Norwich to Tilbury

Document: 9.2 Notification of proposed change to DCO application -
Change Request 2 (Little Bromley)

Planning Inspectorate Reference: EN020027

Little Bromley: Change to the EACN access (Change Request 2)

National Grid plc
National Grid House,
Warwick Technology Park,
Gallows Hill, Warwick.
CV34 6DA United Kingdom

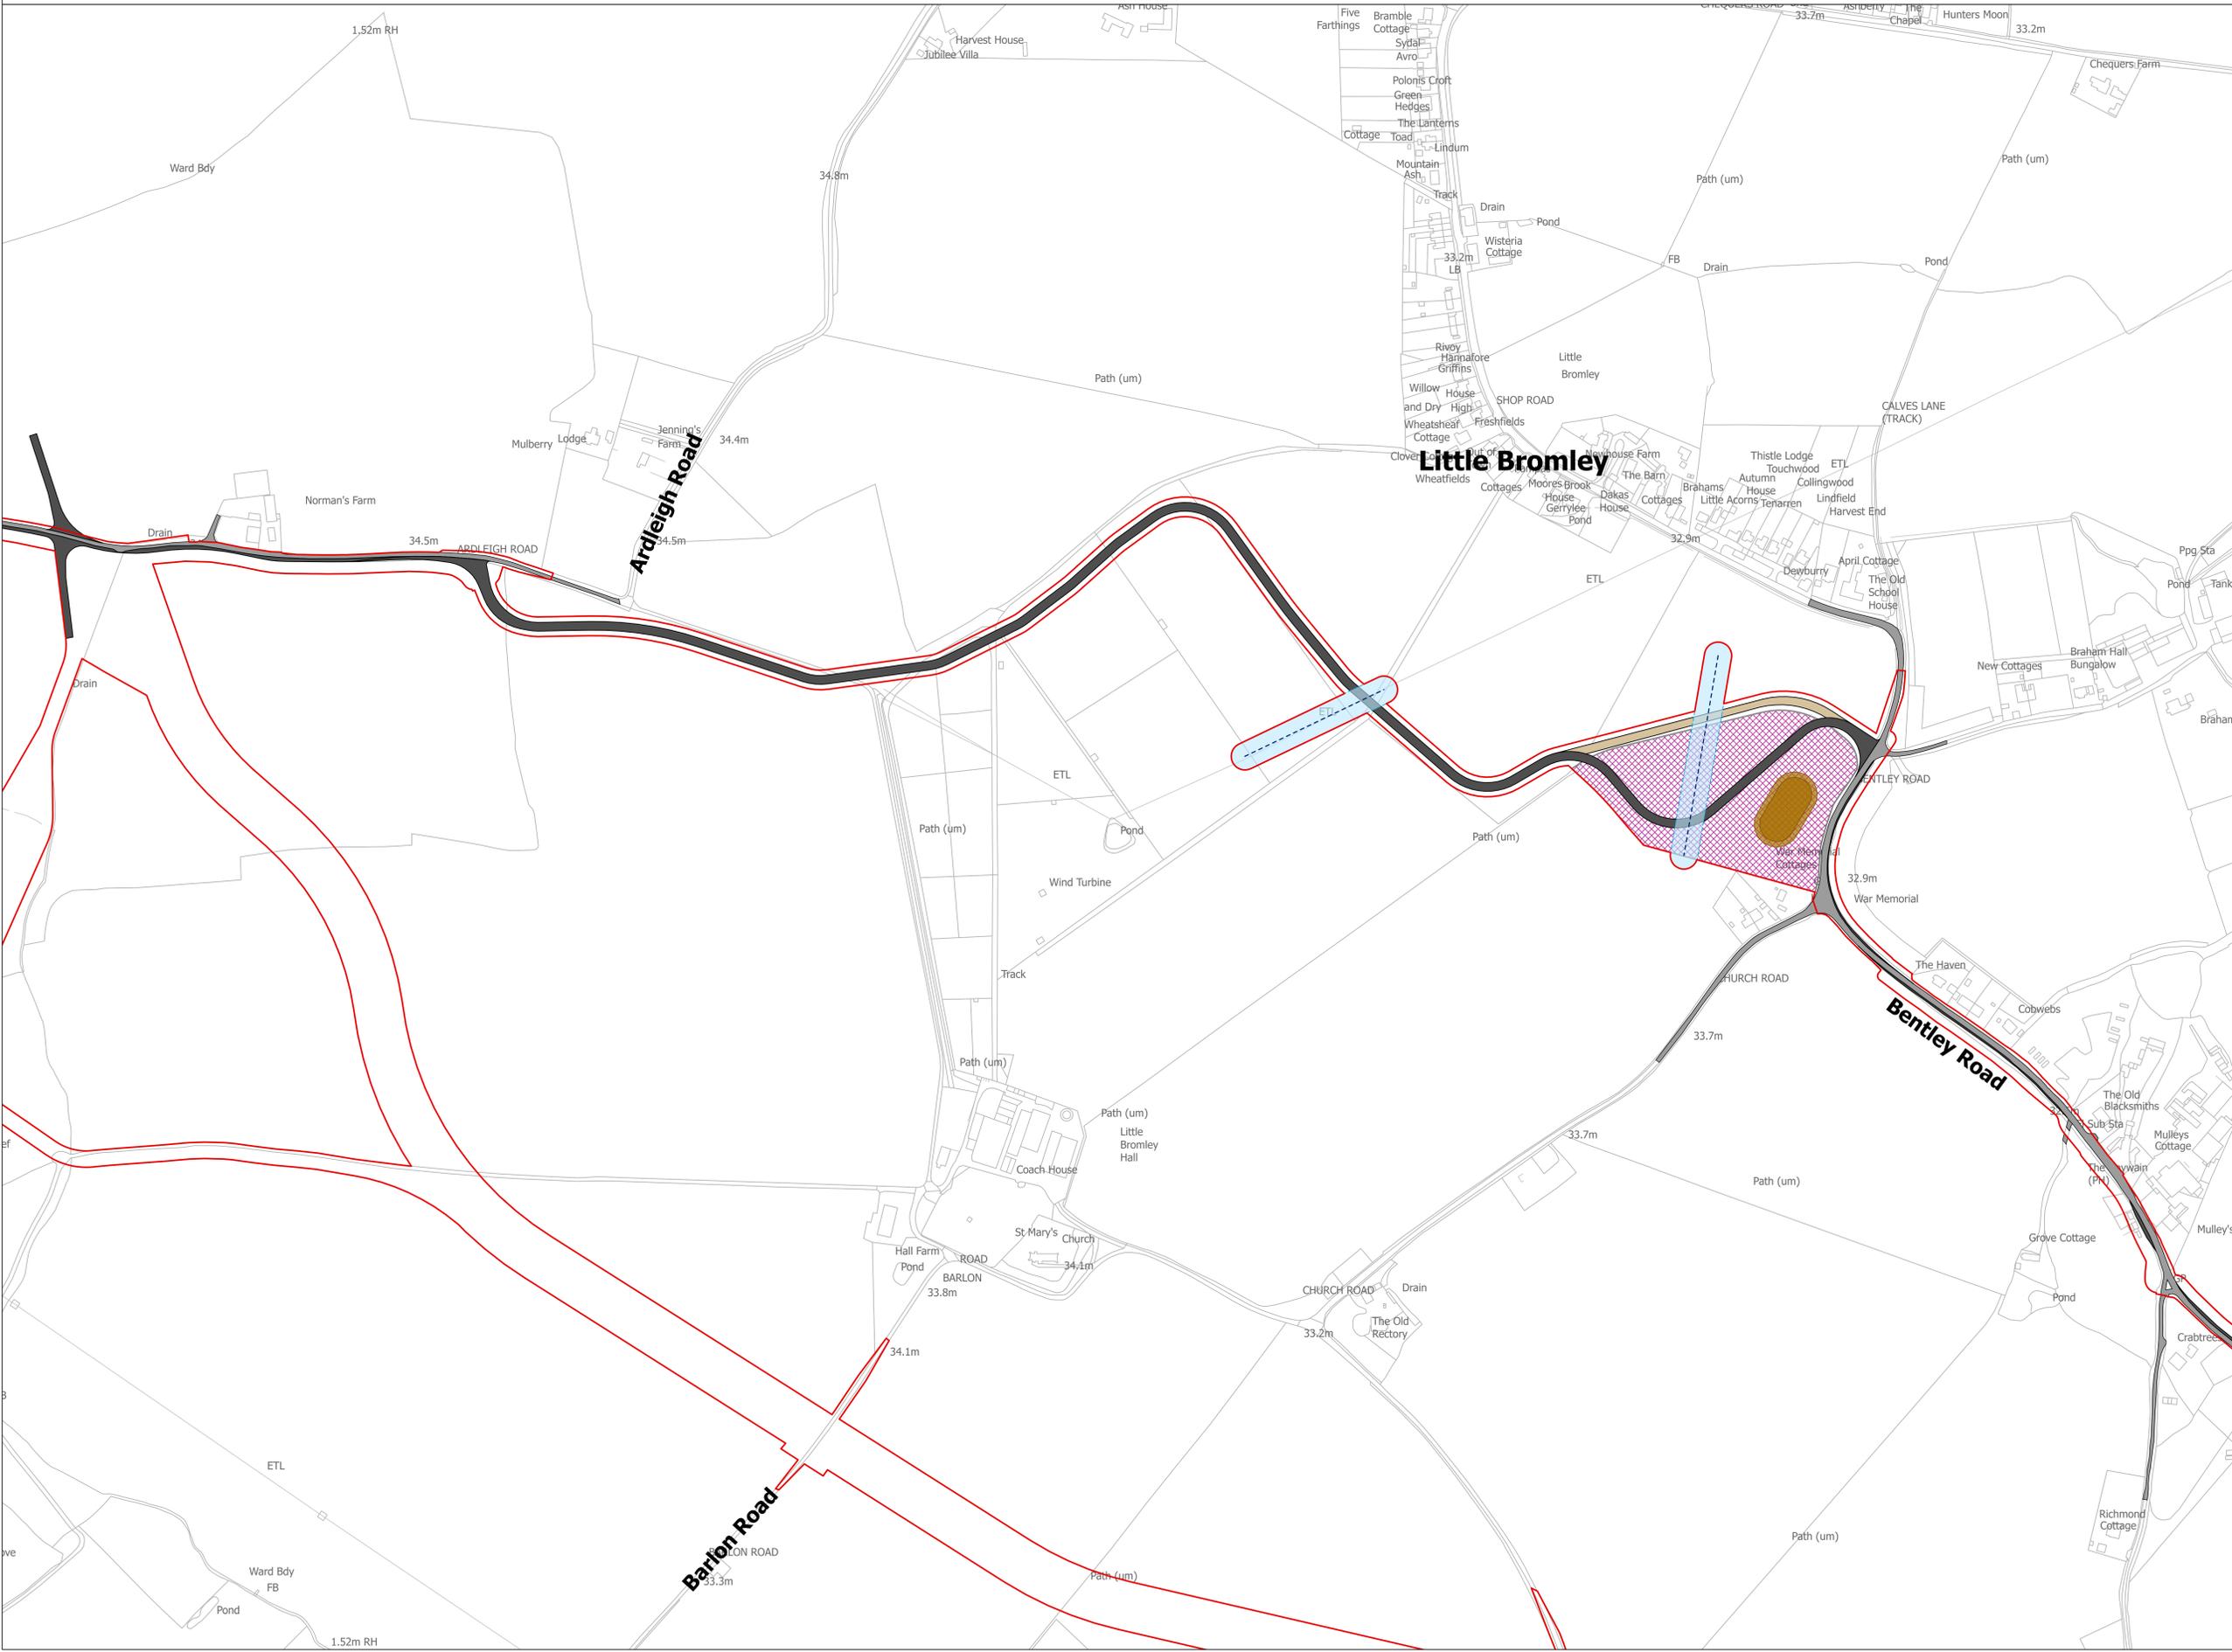
- 2.1.7 Change Request 2 would involve two modifications to the Proposed Route;
- Firstly, a section of the Proposed Route nearest to Bentley Road has been amended to provide a modified alignment for the permanent access relating to Abnormal Indivisible Loads ("AIL") during the operational phase of the Project. The need for a permanent AIL route is to ensure supply standards for the connection are met in the future (by allowing replacement of any component at short notice).

- Secondly, to the northwest of the first modification, the Proposed Route, for both construction and operational vehicles, has been changed back to the alignment presented at statutory consultation between 10 April to 26 July 2024.

- 2.1.8 In both cases, the modifications respond to feedback from, and ongoing detailed discussions with, affected landowners in order to secure an operational access arrangement that meets the Project need whilst also facilitating ongoing land management. The first modification (concerning the AIL arrangement) is intended to minimise the effects of the Project on future arable cropping, whilst the second modification ensures that the Proposed Route more closely follows field boundaries.

- 2.1.9 Additionally, precautionary amendments to existing wood pole supported infrastructure will be accommodated as part of Change Request 2.
- 2.1.10 The Applicant considers that the proposed change will not result in any new or different likely significant environmental effects to those reported in the **Environmental Statement (ES) (APP-123 to APP-287)**. This will be confirmed in an Environmental Statement Addendum Report that will be submitted with the Proposed Change Application 2. The proposed change is not considered to affect compliance of the Project with planning policies detailed in the **Planning Statement (APP-085)** and **Policy Compliance Document (APP-086)**.

- 2.1.11 The arrangement has been subject to extensive discussion and consideration of alternatives with relevant landowners.
- 2.1.12 The Order Limits are to be amended as a consequence of the proposed change, with powers of compulsory acquisition and temporary possession to be sought by the Applicant over the additional land intended to be brought within the Order limits. Accordingly, the CA Regulations are engaged.
- 2.1.13 The Applicant has therefore sought the consent of those landowners to the inclusion within the draft DCO (if granted) of compulsory acquisition powers for new land and rights in respect of the land affected by the proposed change. However, it has not been possible to obtain such consent in advance of issuing this change notification.
- 2.1.14 The proposed change to the Order Limits is shown on the figures in **Appendix A**.
